Approval of reserved matters following outline consent WA/26/18/OUT for layout & scale for 6 No. dwellings & 6 No. detached garages.

Lanes End West Walberton Lane Walberton

Thank you for your internet representation made on 4th March 2019 which has been recorded as '**an objection**' with the comments as follows:

PJ DEVELOPMENTS LTD 2 Square Chambers 23 High Street Emsworth PO10 7AQ Tel: 0843 289 3430 Email: enquiries@pjdevelopmentsltd.com	
PROJECT: FORMER LANES END	
SITE PLAN OUTLINE PLANNING APPLICATION	
DATE: JANUARY 2019	DWG. NO 19-001 PL02
SCALE @ A1: 1:200	
REV: C

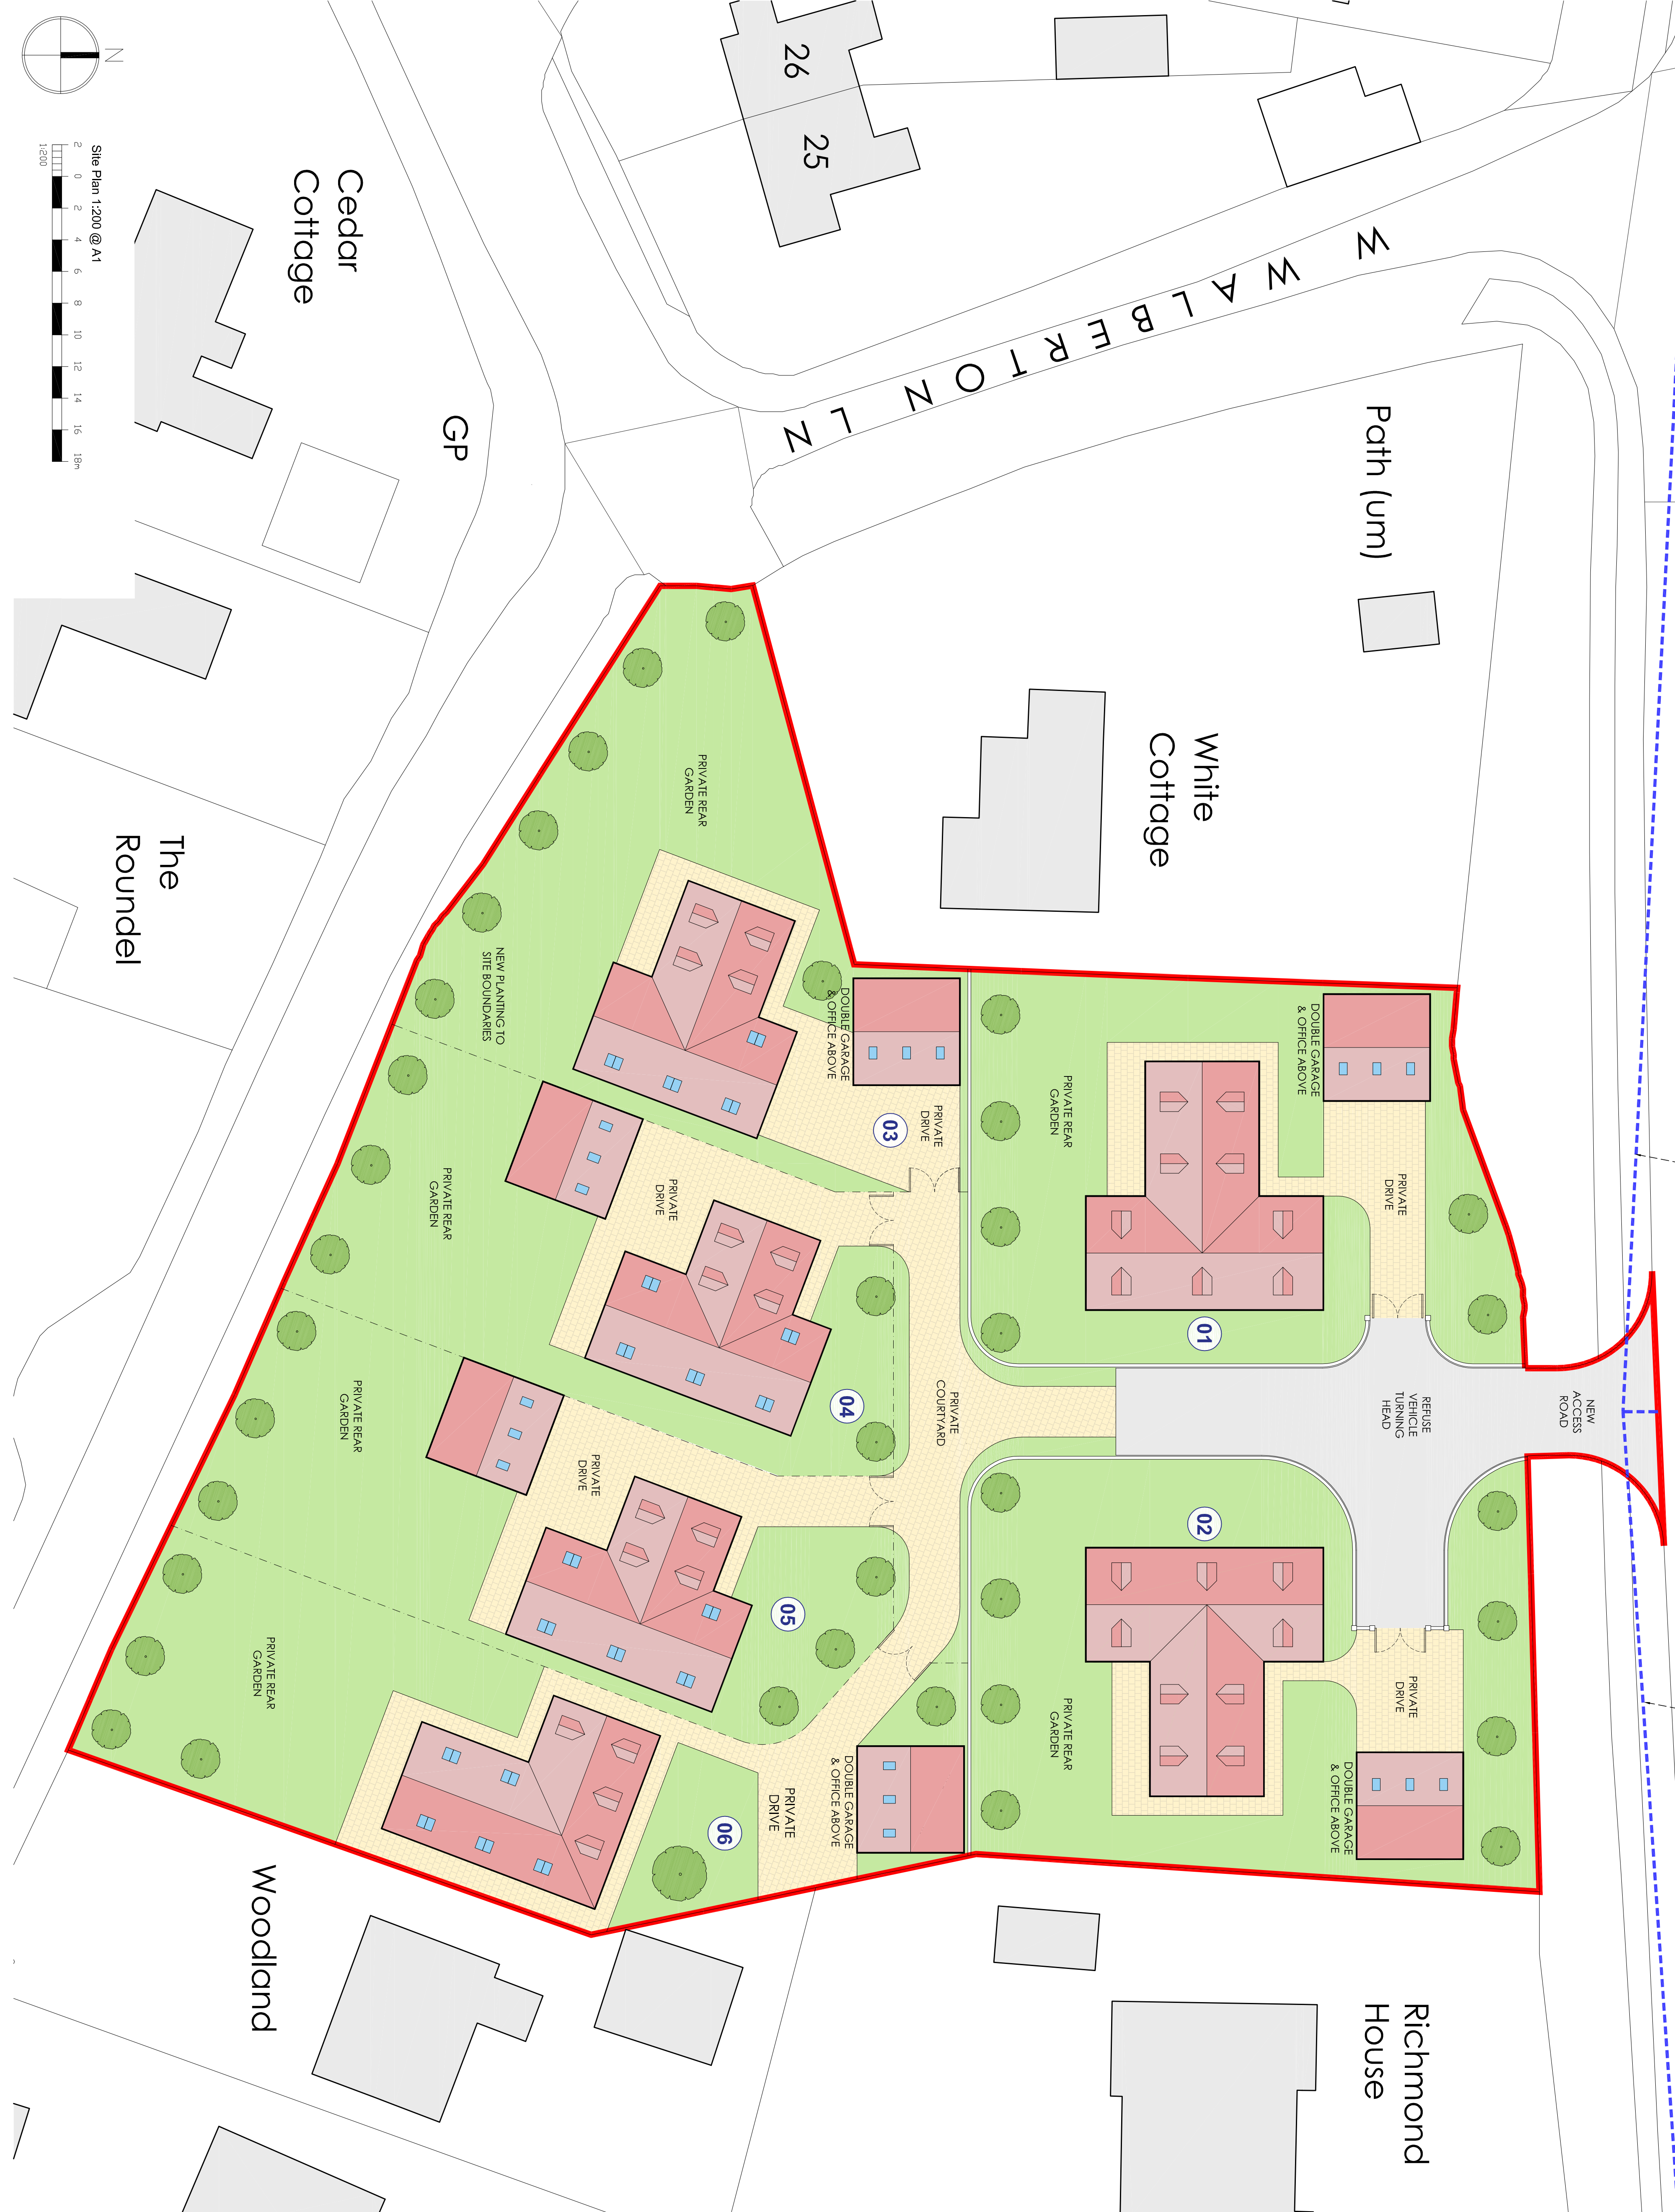
The layout is not in accordance with the Applicant's response dated 27 June 2018 to Arun's Arboriculturist Objection dated 20 June 2018. The Applicant's response stated that all mature trees on the boundary of the property remain. None of the mature trees on the border in close proximity with my property are shown on the drawing accompanying this Application.

PLOTS 1 AND 2 FLOOR PLANS AND ELEVATIONS

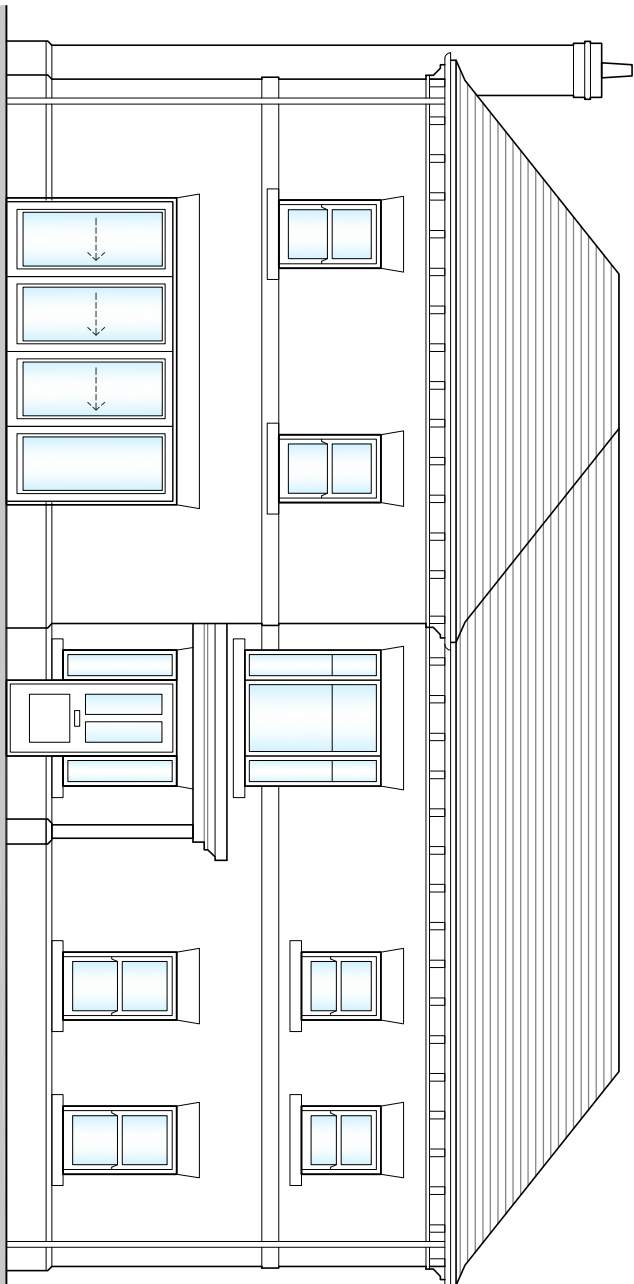
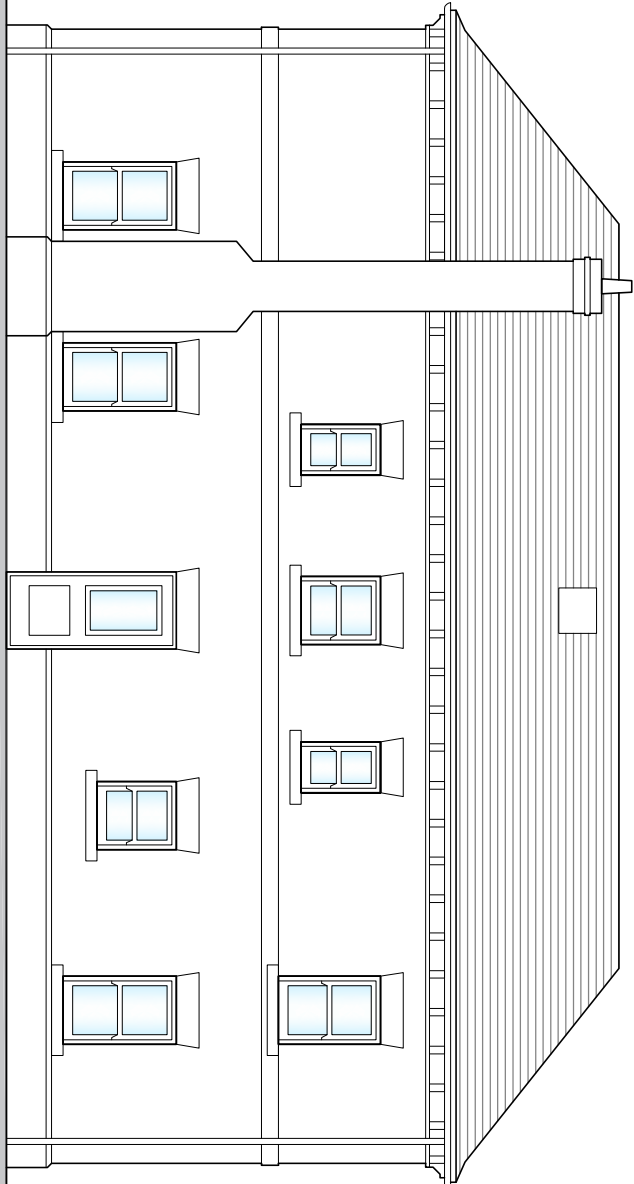
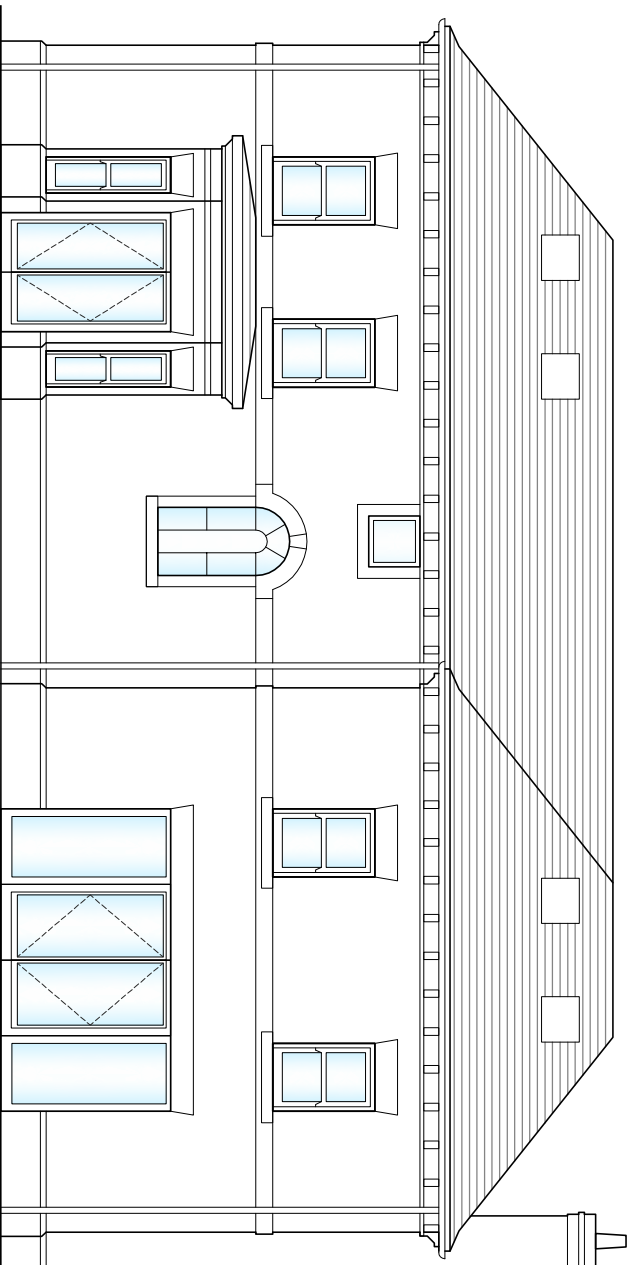
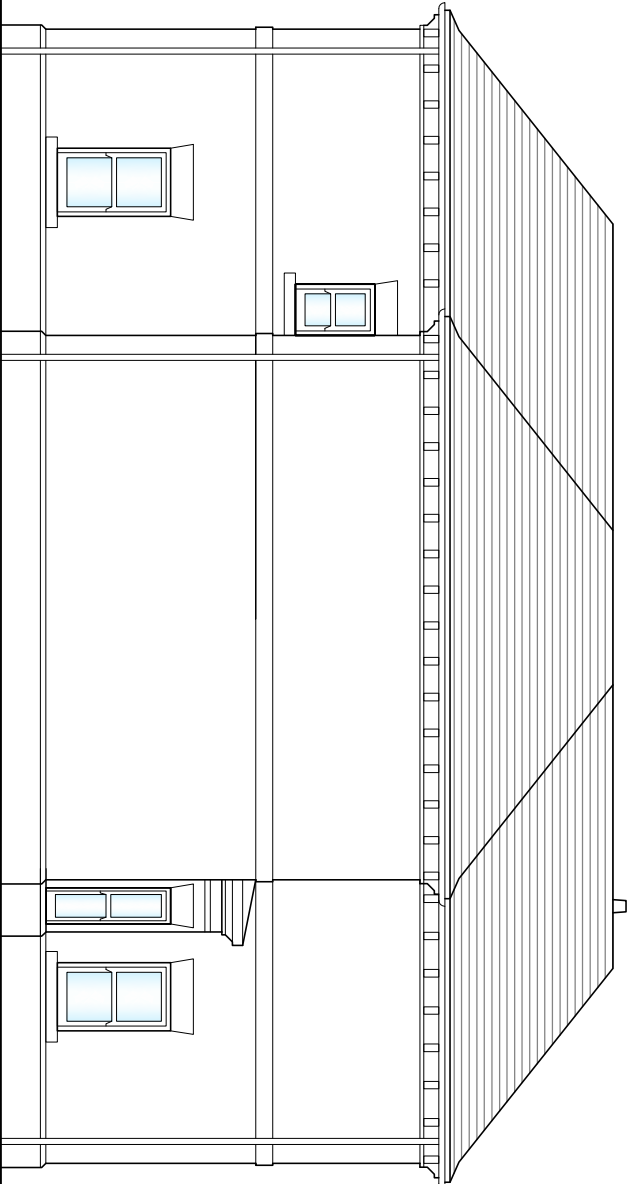
It would appear that the roof windows of the nearest property to mine look into my side bedroom so need to be of obscured glazing and not openable. There is no side elevation but this requirement applies to all upstairs windows facing my property.
